The Member Secretary  
Chennai Metropolitan  
Development Authority,  
No. 1, Gandhi Irwin Road,  
Egmore, Chennai-600008.

Letter No. B1/530/2005.

Sub: CMDA - Area Plans Unit - Planning Permission - Proposed Construction  
of still partially flow + 4 floors residential building with  
4 (four) dwelling units at plot no: 6/A, & no: 4 (old no: 54)  
Bishop Garden road, RA puram, R.S.No: 3958/119 & 3958/120  
Block no: 87 of Mylapore village, Chennai - Resubmission of layout-Reg.  
Ref: 1) PPA received in SBC No 16/2005 dt 6.1.2005.

SECTION - AA

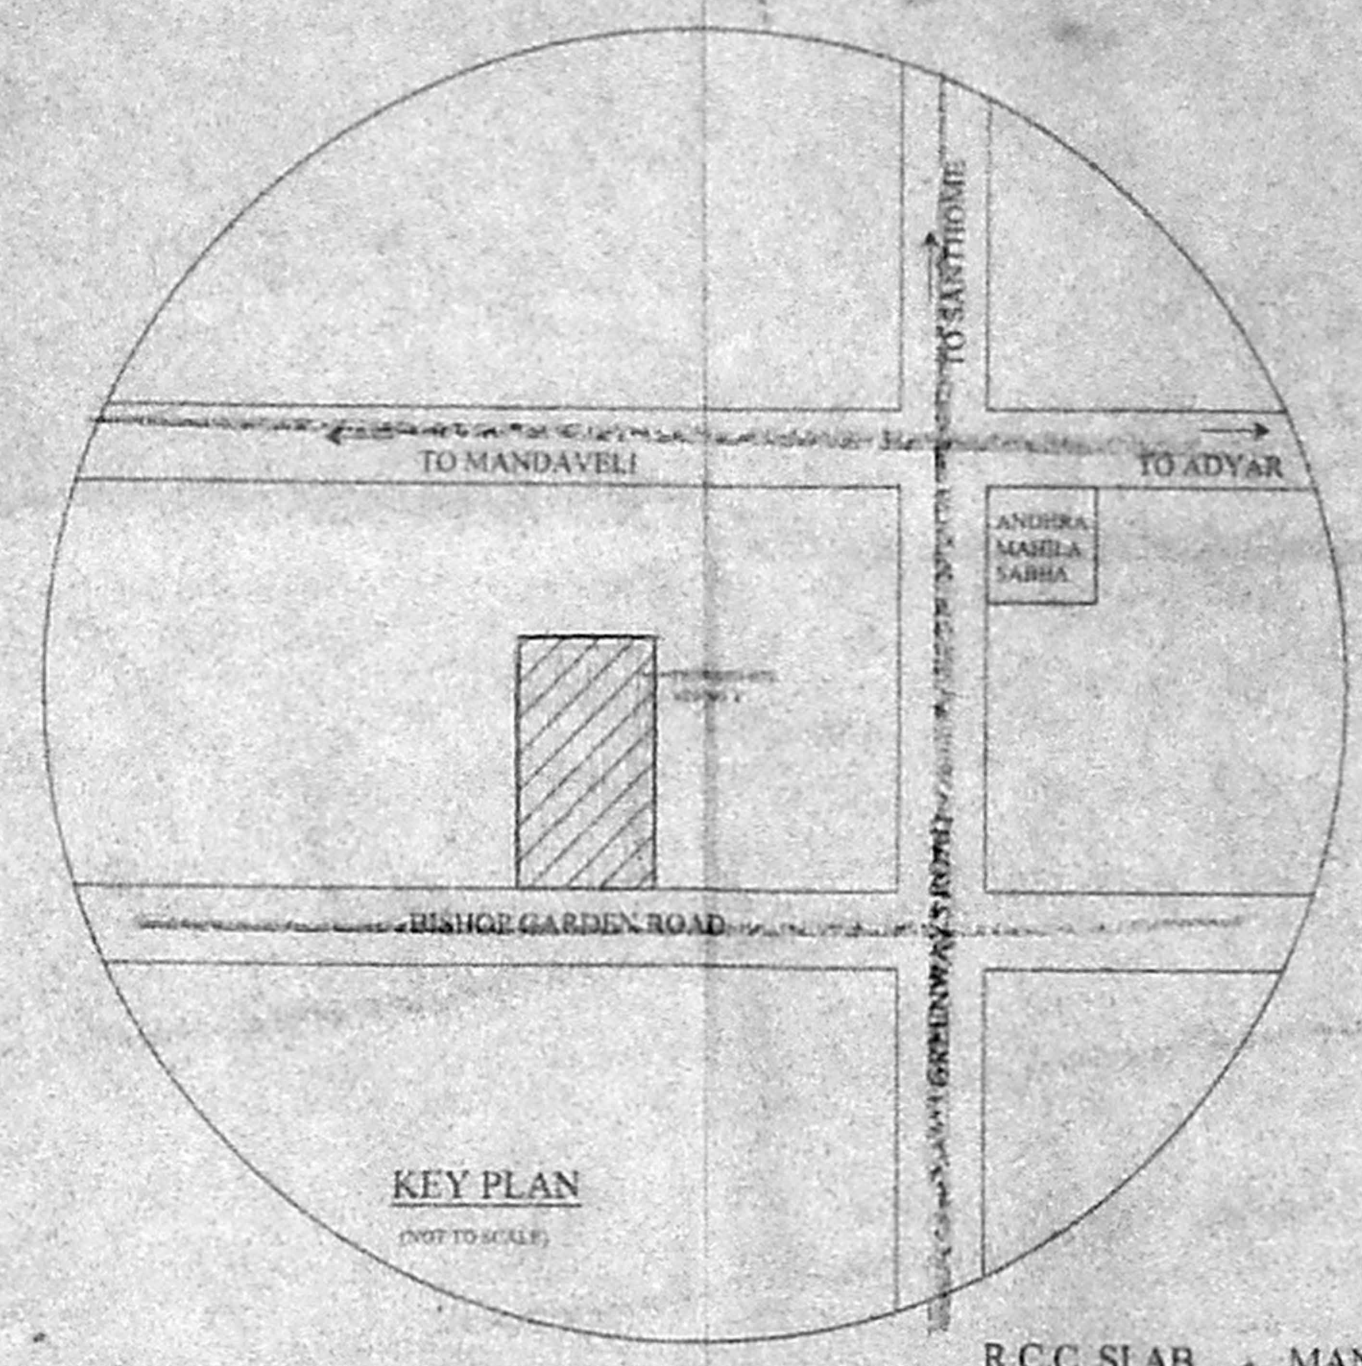
- i) The proposal violates DC rules in respect of FSI (currently 3.25 m<sup>2</sup>).
- ii) The height of still in mks system shall be indicated as "2.20 mt".
- iii) Site plan shall be redrawn showing both the site dimensions as on site and as per plan correctly and distinguishing the difference by hatched indication and indicating the setbacks perpendicular to the least site boundary line. Shape of site does not reflect as per the measurements.
- iv) The Total height of structures in elevation plan require correction.
- v) Area statement need correction.
- vi) Access to open terrace in 4th floor, shall be provided.
